Application No: M/68/20/PL
Site Address: Poultry Farm 87 Yapton Road Middleton-On-Sea PO22 6DY
Description of works: Demolition of the existing structures & redevelopment to provide a new 66-bedroom care home arranged over two storeys together with associated access, car & cycle parking, structural landscaping & amenity space provision (resubmission following M/80/19/PL). This application is in CIL Zone 4 (Zero Rated) as 'other development'.

Thank you for your internet representation made on 30th September 2020 which has been recorded as an objection with the comments as follows:

Tree Protection Plan

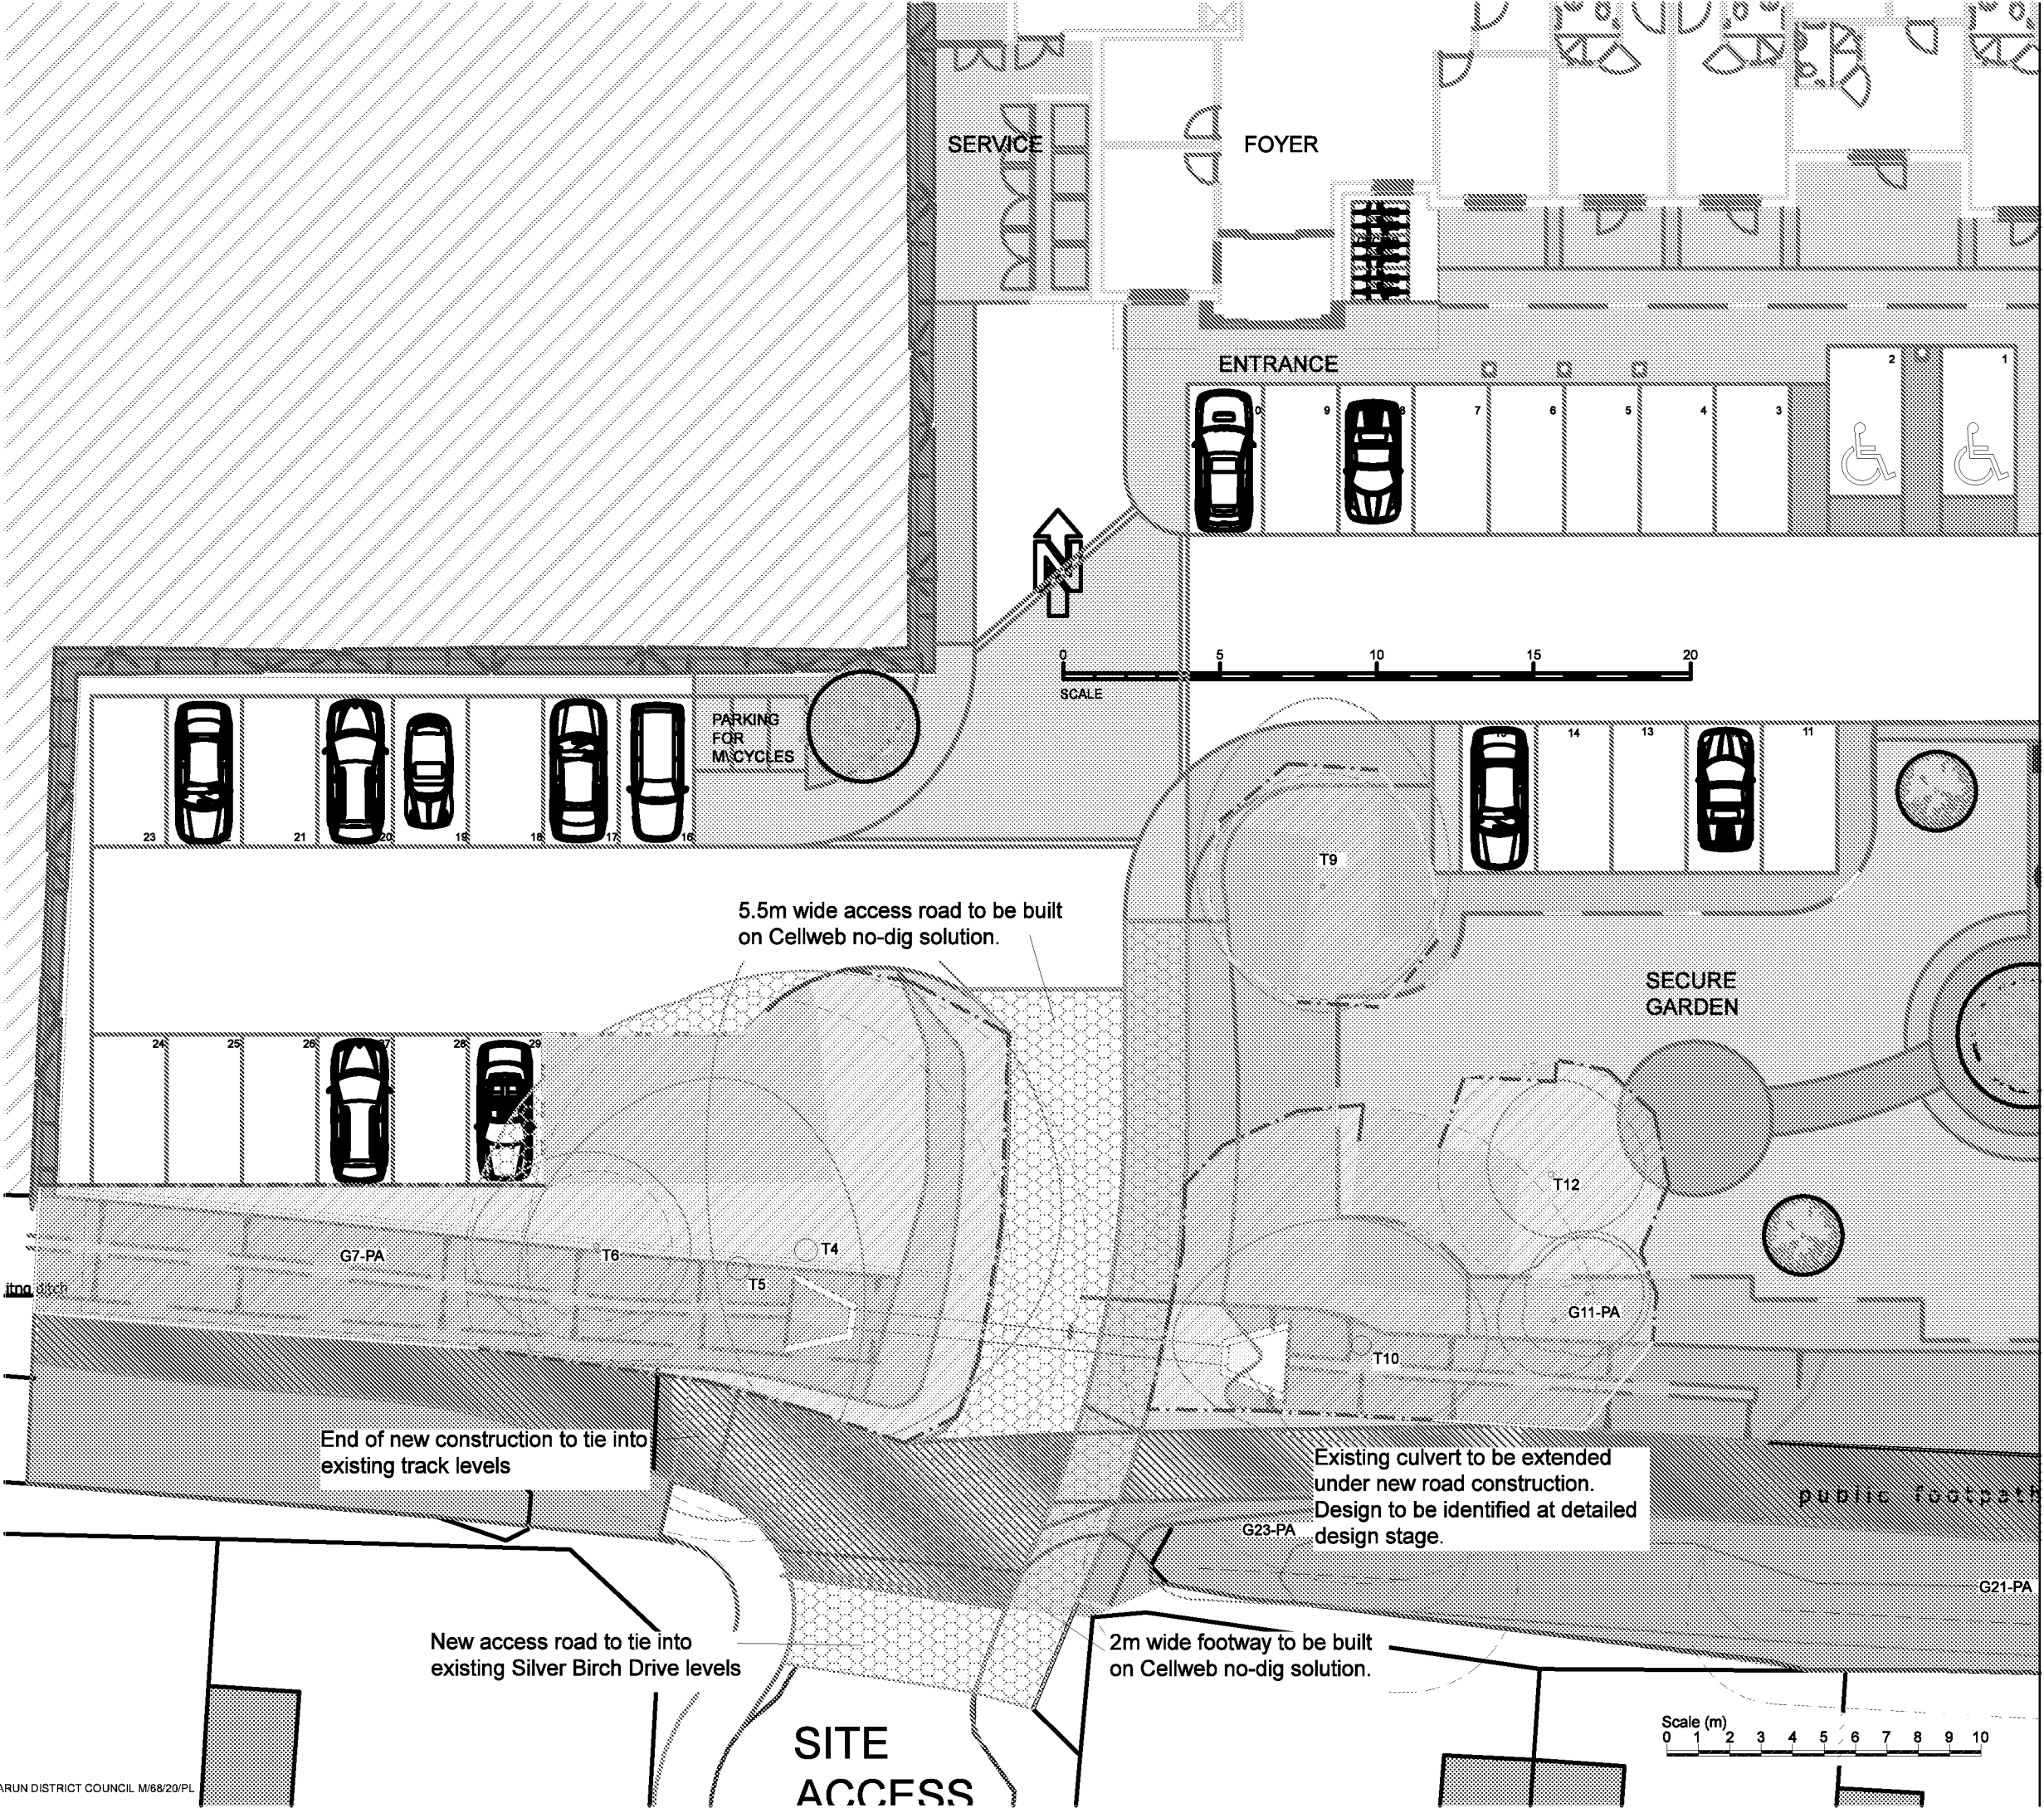
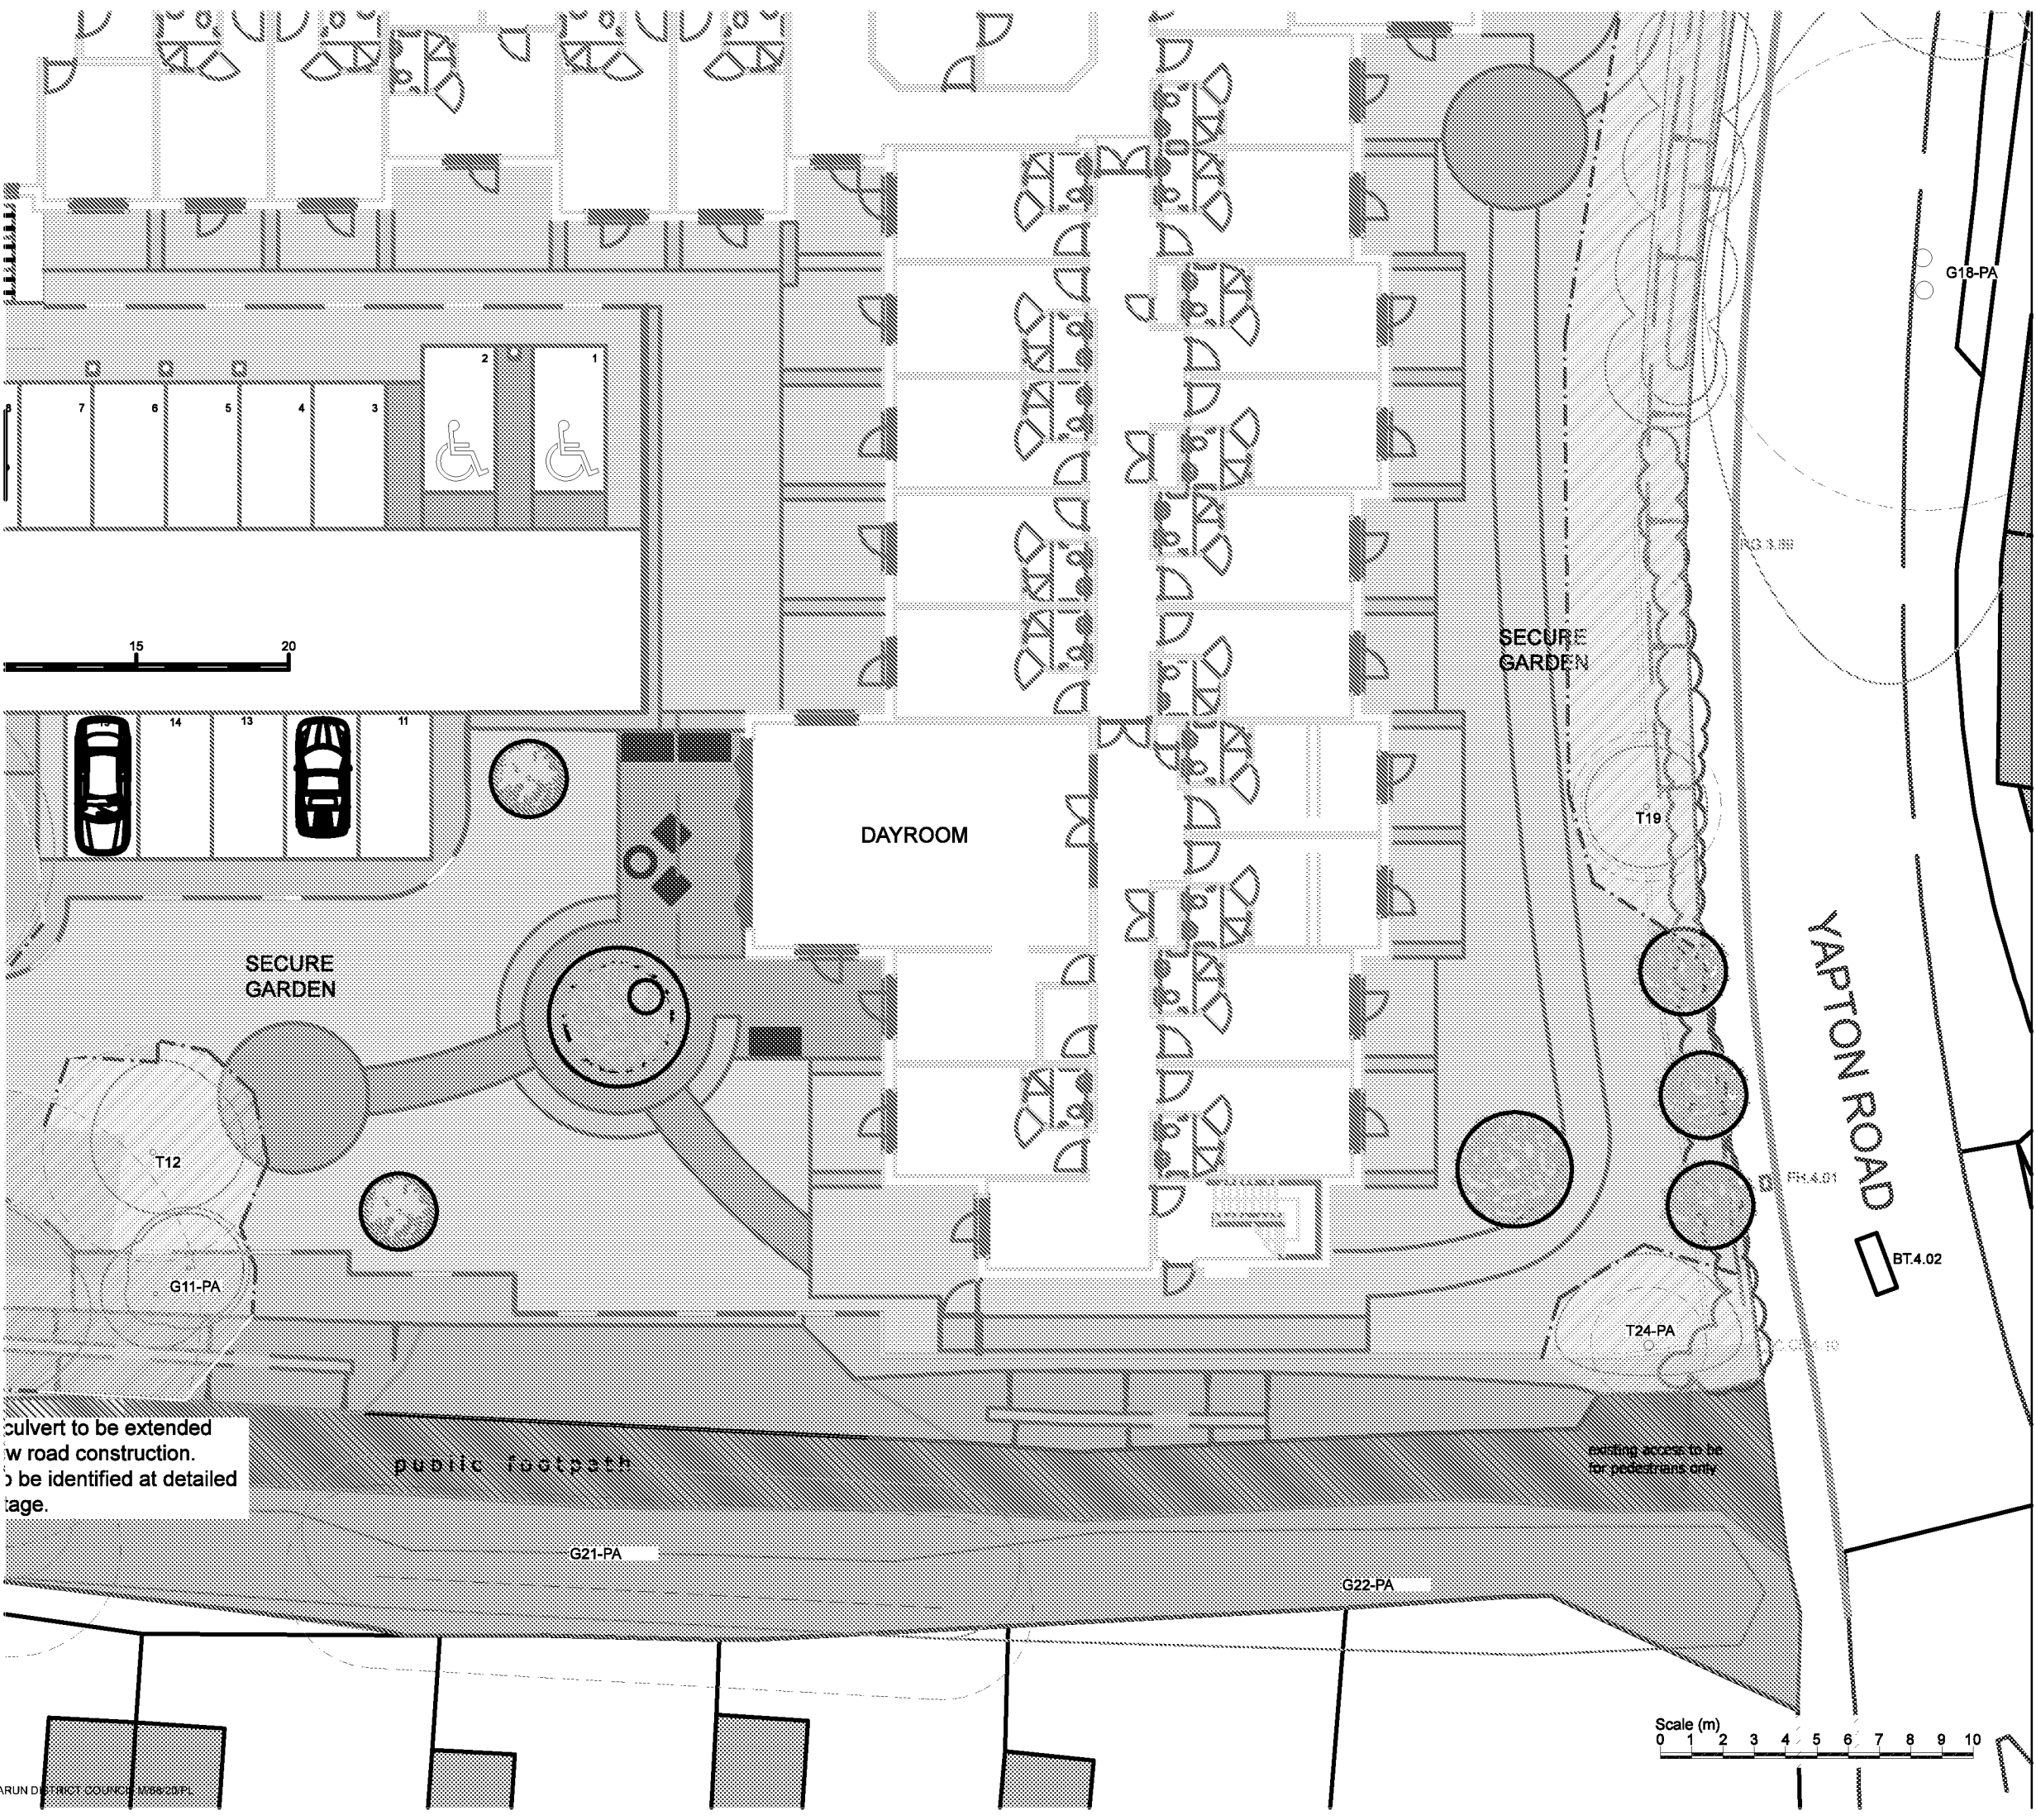
Why have all the protected trees got new numbers?

This is very confusing and we would not want the wrong trees to be chopped down by mistake by anyone would we?
